Response to Planning application from Hertfordshire County Council (T and CP GDP Order 2015)

District ref: 6/2023/1124/FULL
HCC ref: WH/17057/2023
HCC received: 22 August 2023
Area manager: Manjinder Sehmi
Case officer: Senober Khan

2 Hill Rise Cuffley Potters Bar EN6 4EE

Erection of 5 bedroom dwelling following the demolition of existing dwelling

Site Plan 1:200 Scale

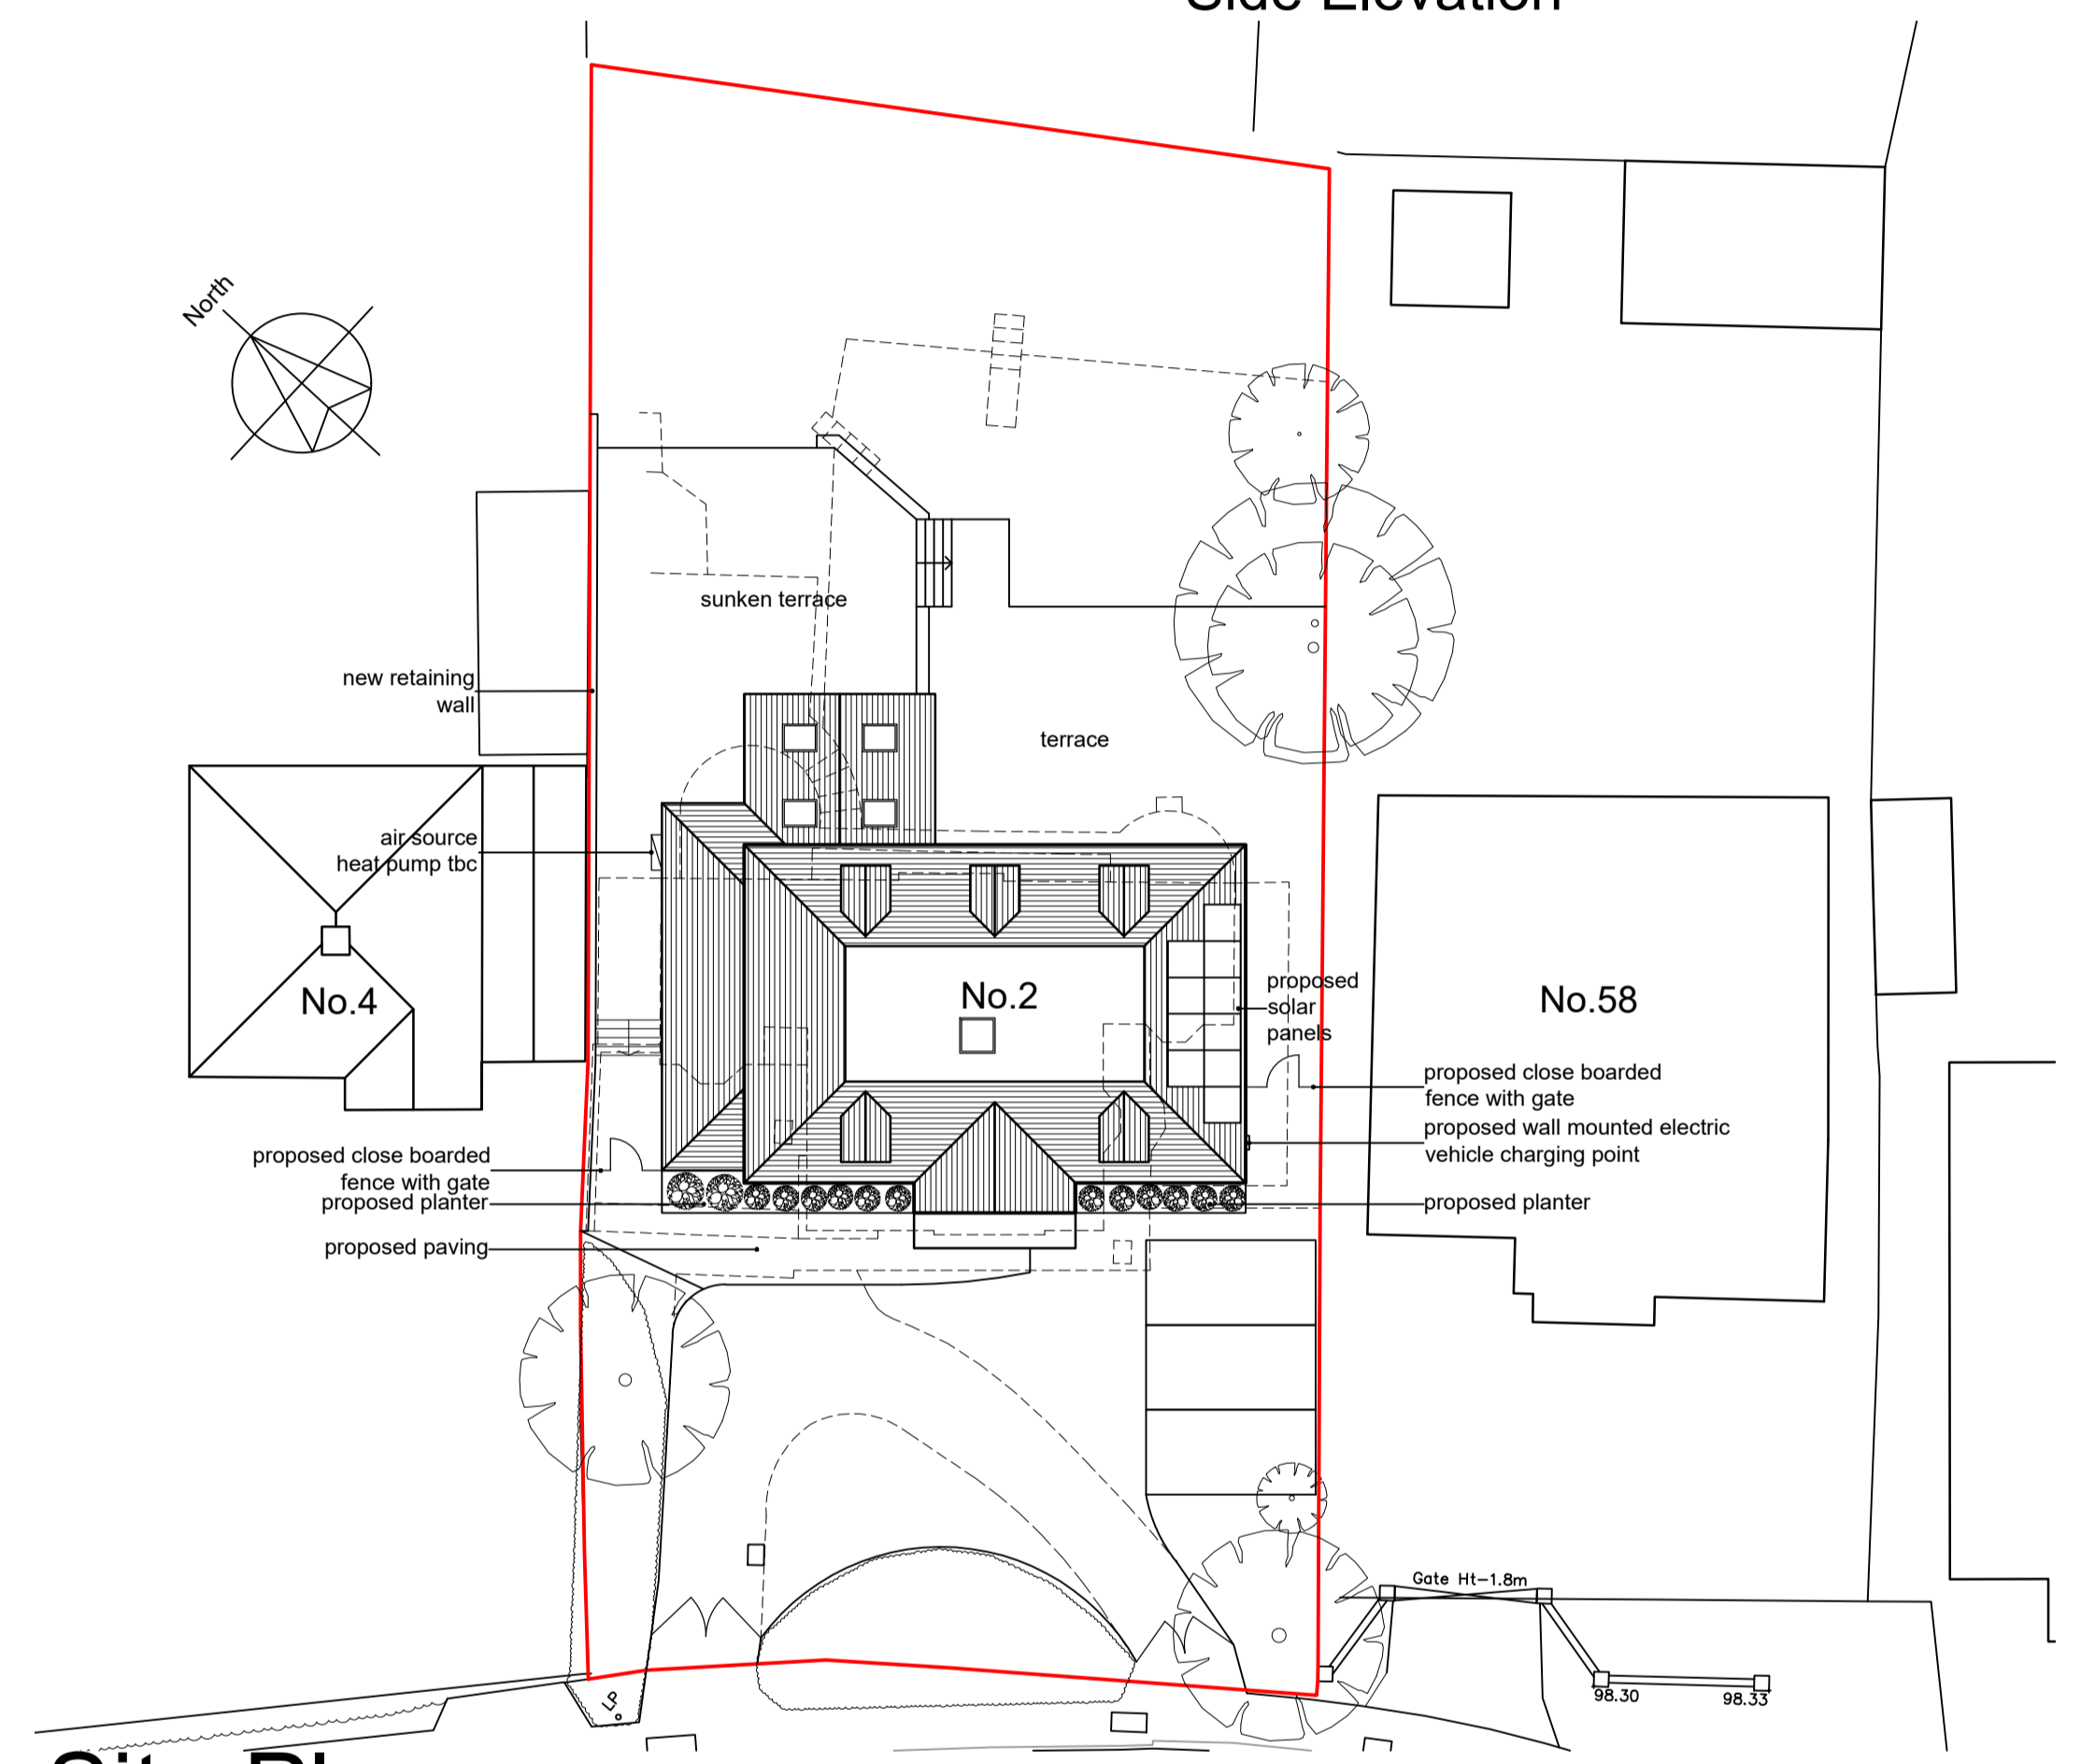
The site has 2 existing vehicle accesses and a long frontage, there is scope for a better positioned vehicle access to be provided, located as far away as possible from the driveway opposite the north part of the site. The sites southern vehicle access should be considered provided it can achieve the required forward visibility splays and pedestrian visibility splays.

With regards to pedestrian visibility splays, the consultant is correct that under the current and emerging guidance visibility splays of 0.65m x 0.65m are acceptable and should be provided.

The siting of any gate should be set back by 5.5m from the back of the public highway, the consultant has stated there remains space within the site to provide this, the HA would insist that this be accordingly provisioned for reasons already provided in the previous comments.

The applicant is reminded that only one vehicle access will be permitted and that the applicant will be liable for the cost of returning the redundant crossover/ dropped kerb back to footway.
